**KIRKLEES METROPOLITAN COUNCIL
INVESTMENT & REGENERATION SERVICE**

DELEGATED DECISION TO DETERMINE PLANNING APPLICATIONS

Reference No:	2022/62/91188/W
Site Address:	100, St John's Road, Birkby, Huddersfield, HD1 5EY
Description:	Erection of single and two storey side and two storey rear extensions to increase ground floor retail unit and HMO above (within a Conservation Area)
Recommending Officer:	Katie Chew

DECISION - Refuse

BLOCK PLAN

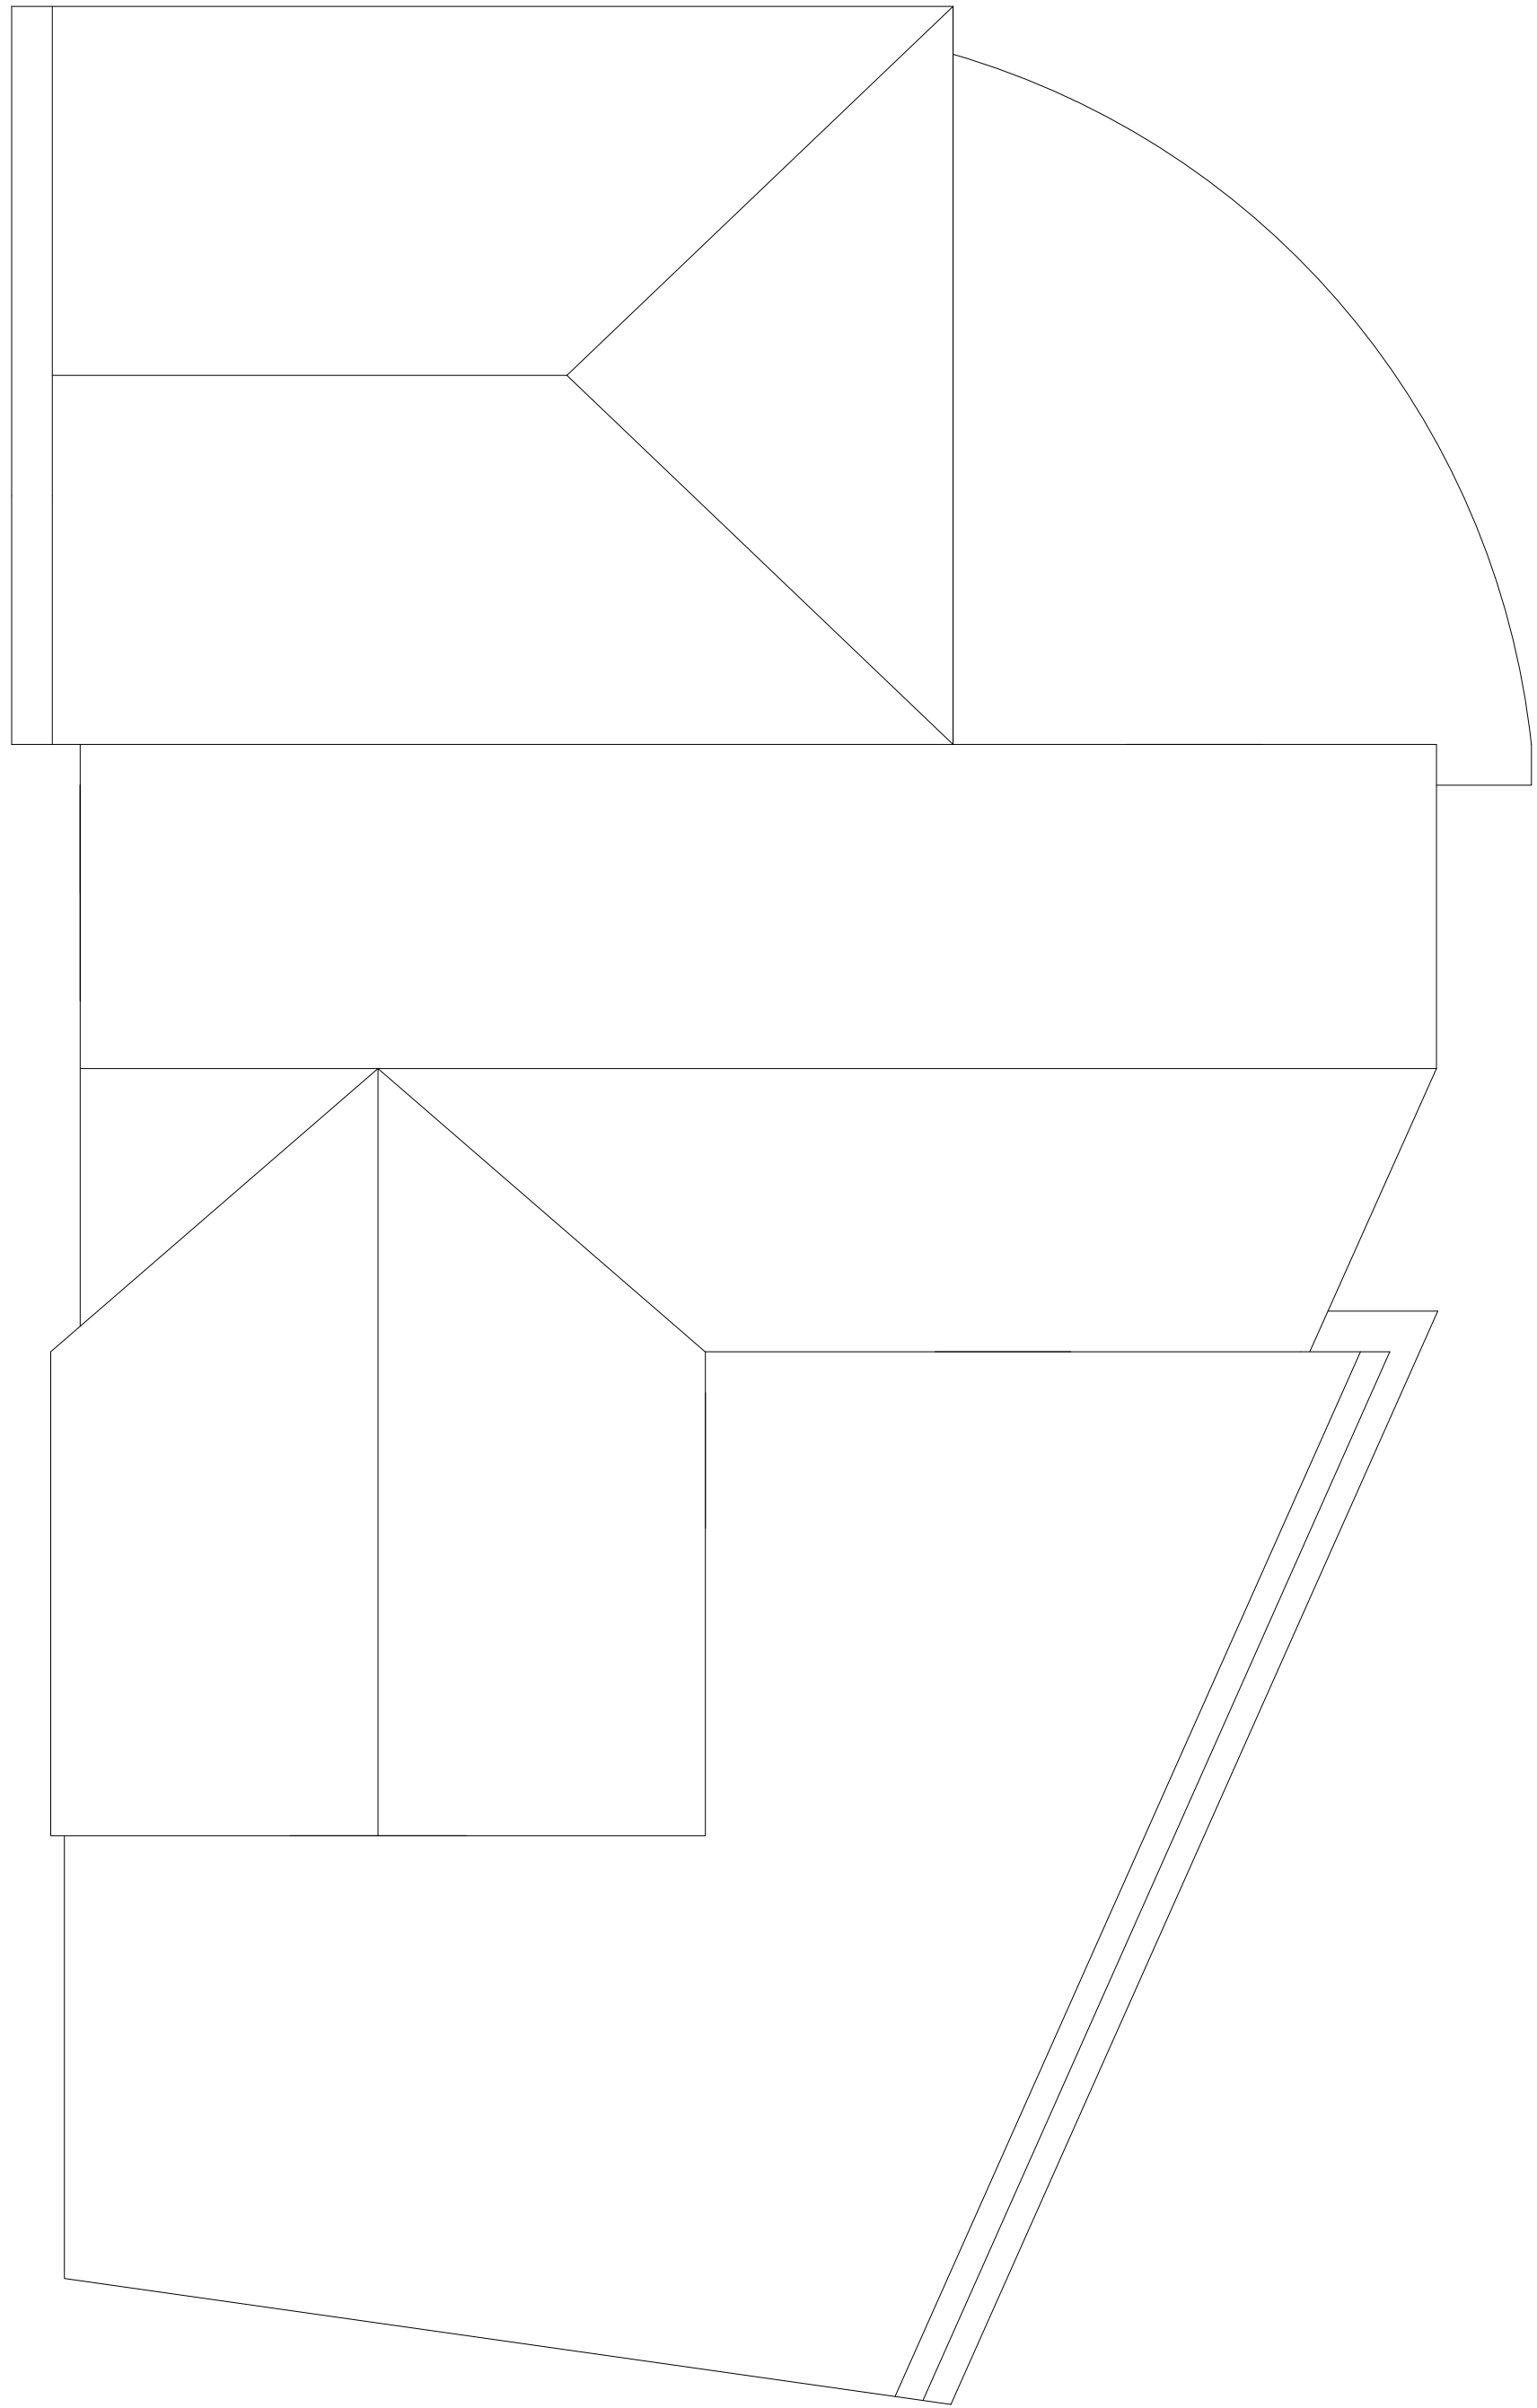
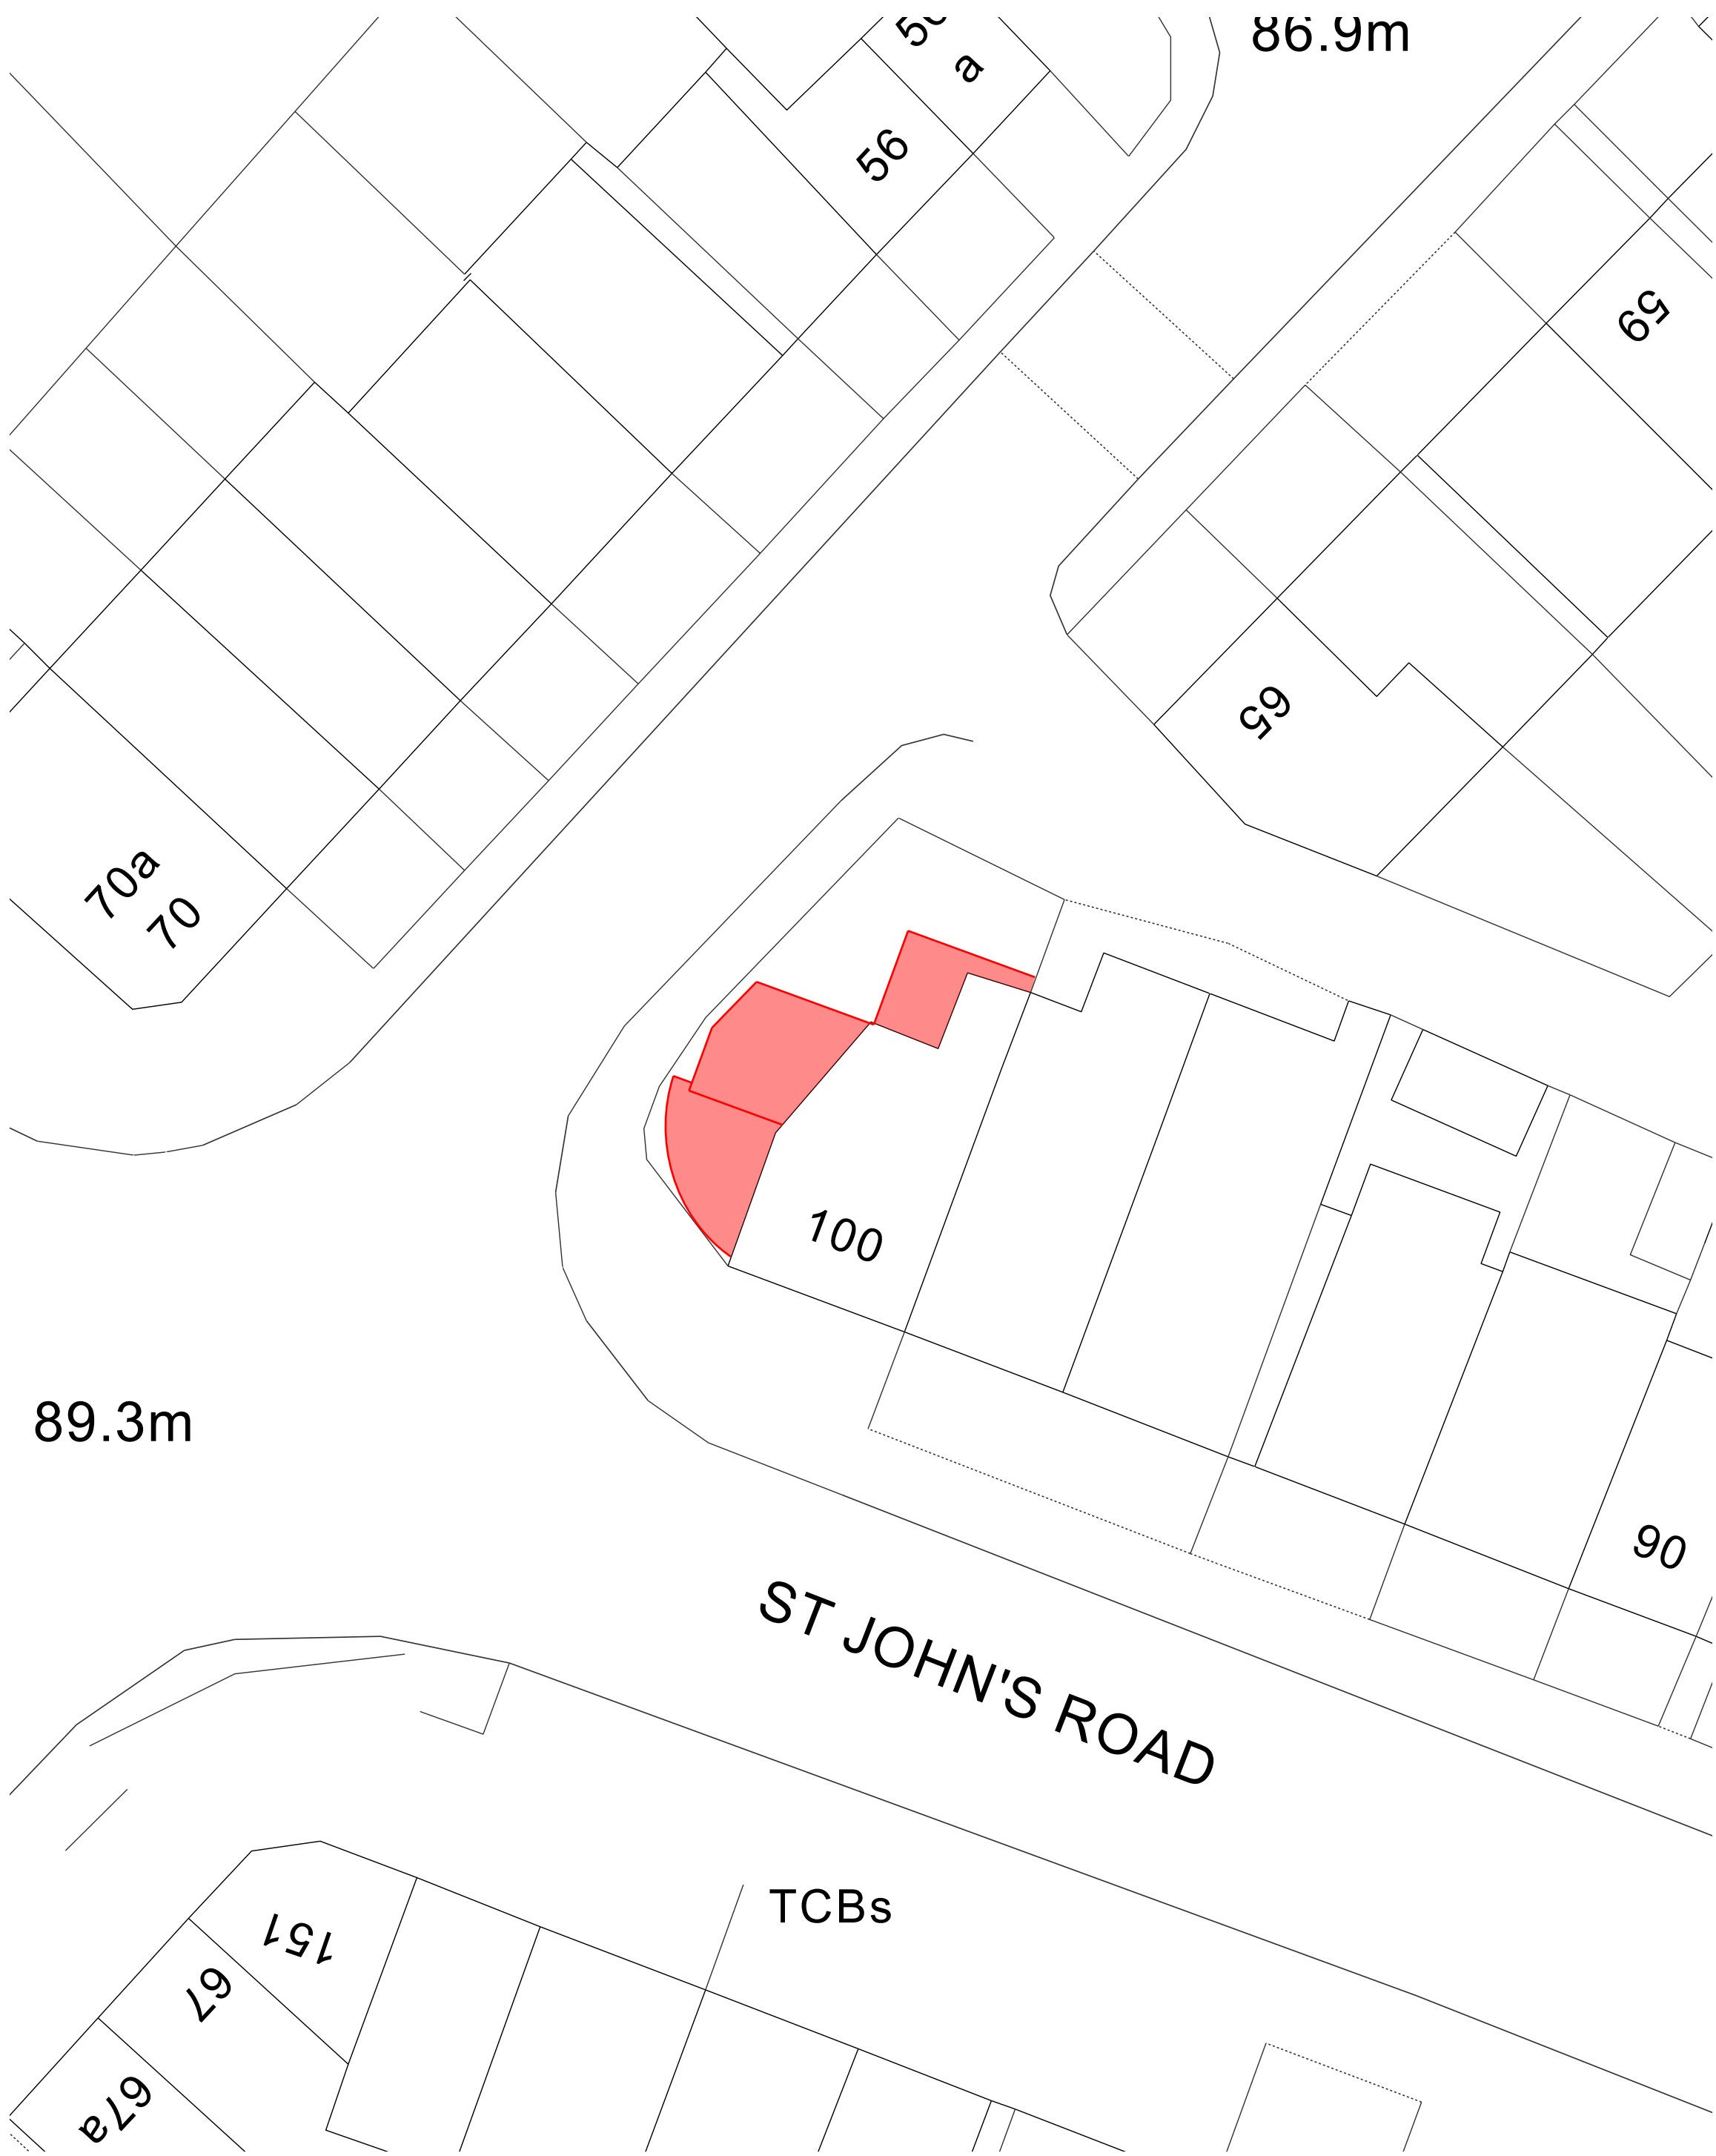
In this instance the proposals seek to build out up to the western boundary, leaving minimal/no space between the extensions and the public highway, and only a limited amount of amenity space would be retained to the area. The side extensions, due to their scale and siting close to the highway of Blacker Road would be dominant and oppressive features from within the highway. Of note, other properties to the north east on Blacker Road are slightly set back from the highway boundary.

A bin store is shown on the submitted plans to the rear of the site. Highways officers raise concerns with this proposed location as it would be set behind the proposed parking area and so would not be accessible for a collection crew. Highway officers would therefore like to see a collection presentation

point marked clearly on a drawing in an accessible place which would not obstruct the access to the parking/delivery space or the highways/footways for road safety reasons. Should planning permission be granted, this could be secured via a condition.
